Date: 27 January 2015
Our ref: 138185
Your ref: 14/01932/OUT

Planning consultation: Outline - Development of up to 1,000 dwellings together with a mixed use local centre, primary school, green open space etc.

Location: OS Parcel 7400, Adjoining And South Of Salt Way, Banbury

Figure 14 - Development Framework Plan

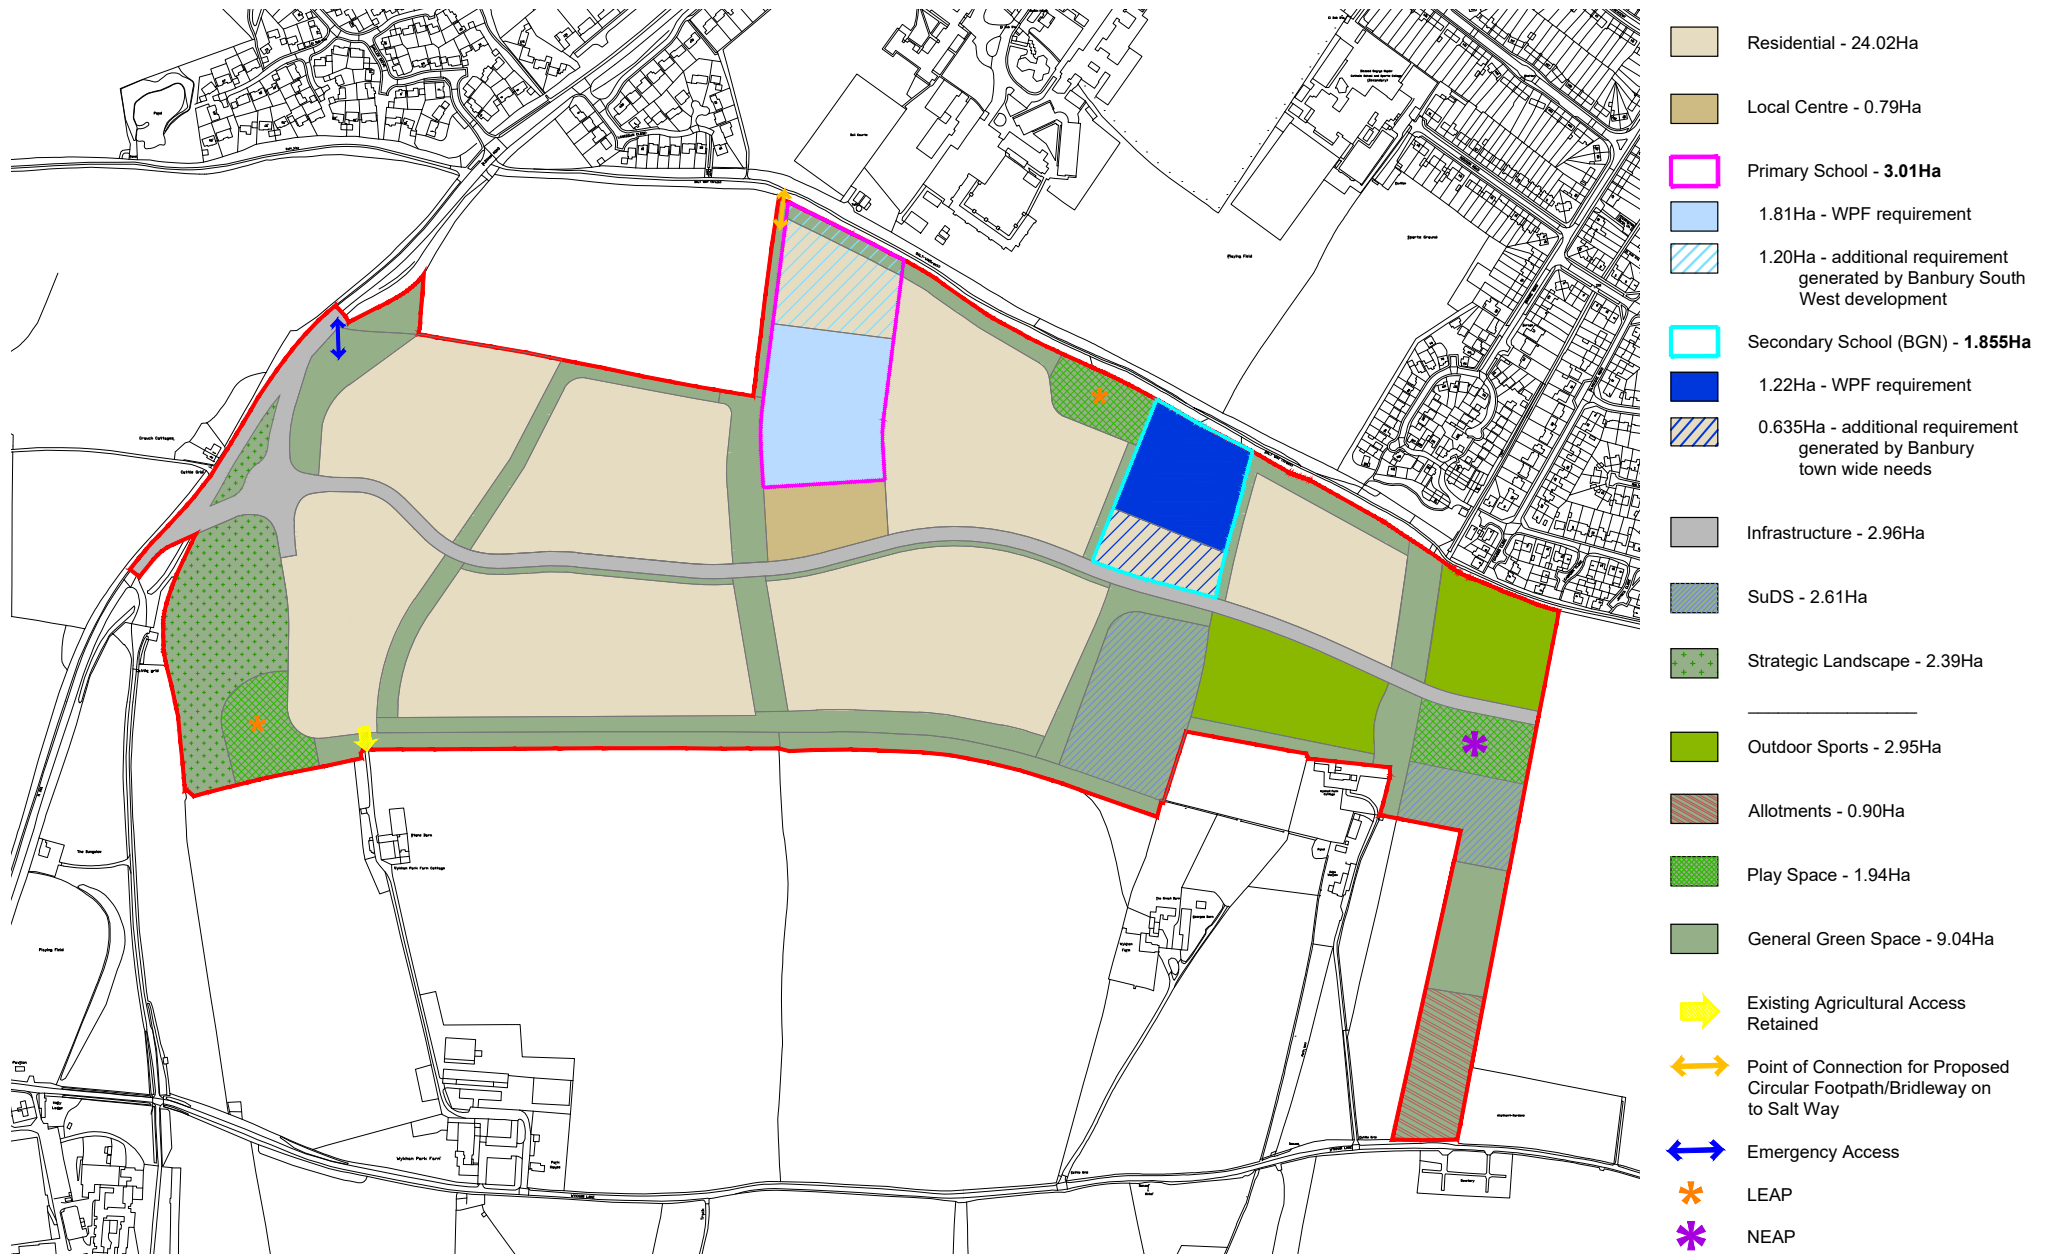
3. The application (outline) layout (Development Framework Plan) does potentially retain some of the BMV land in 'soft uses' as it tends to occur around the periphery of the development. This would appear to be a coincidence, as the applicant's ALC survey has a different distribution of ALC grades.
4. Government policy is set out in Paragraph 112 of the National Planning Policy Framework which states that:
